# CITY OF ALBUQUERQUE

PLANNING DEPARTMENT – Development Review Services

**RE: Eagle Crest Subdivision (File: C18D064B)  
Drainage Report (stamped 7-3-14) and Supplemental calcs(stamped 8-1-14)  
Grading and Drainage Plan, Engineer's Stamp Date 8-1-14**

PHASE 4

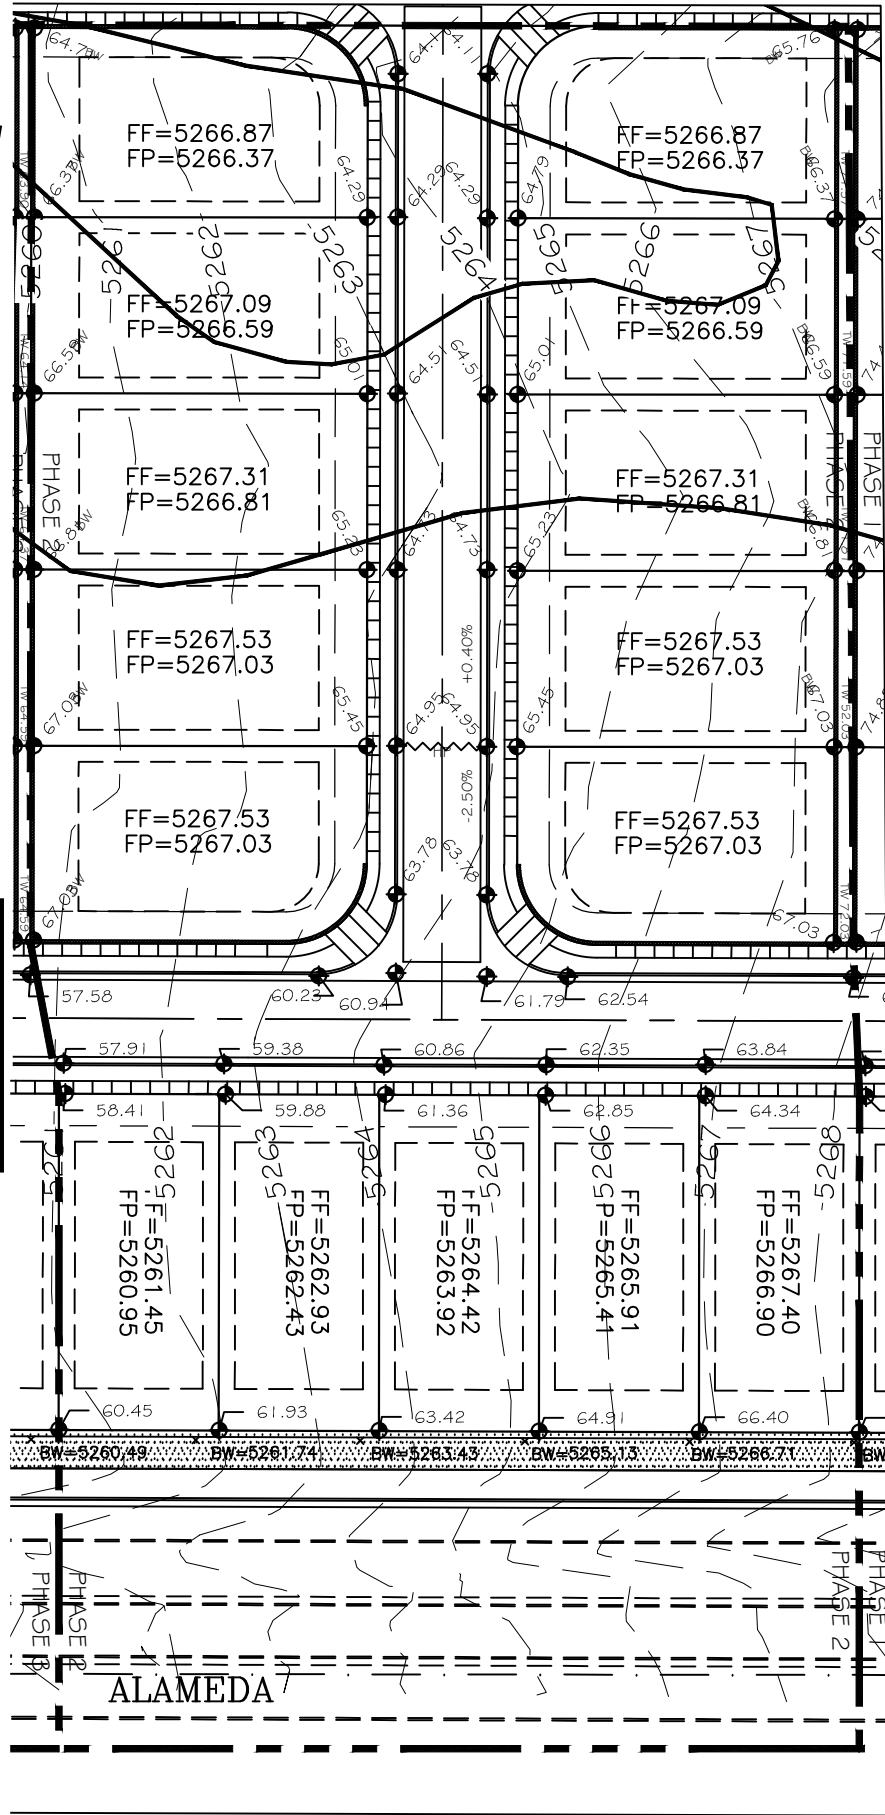
1. Interim Ponds need to be sized and graded on grading plan with WSEL, Vol. and emergency overflow locations. Plats must show a public drainage easement to be maintained by the developer.

5. Define limits of offsite basin "Remainingoak Basin" on a basin boundary map.
6. Use a Match line to continue the Alameda frontage plan.
7. Proposed retaining wall and screen wall are difficult to differentiate. Change the hatch pattern on one or the other.

8. Show spot elevations at retaining walls
9. Update the Unit basin calculation, mainly the narrative and water harvesting in the front yard.
10. Basin map –show limits of basin per phase with different line type or color or both. It looks like B1 and B2 were reduced.

11. Water harvesting ponds – show contour elevations. Appears that another contour is needed.
12. Show flow arrows, proposed contours, street slopes, and street names.
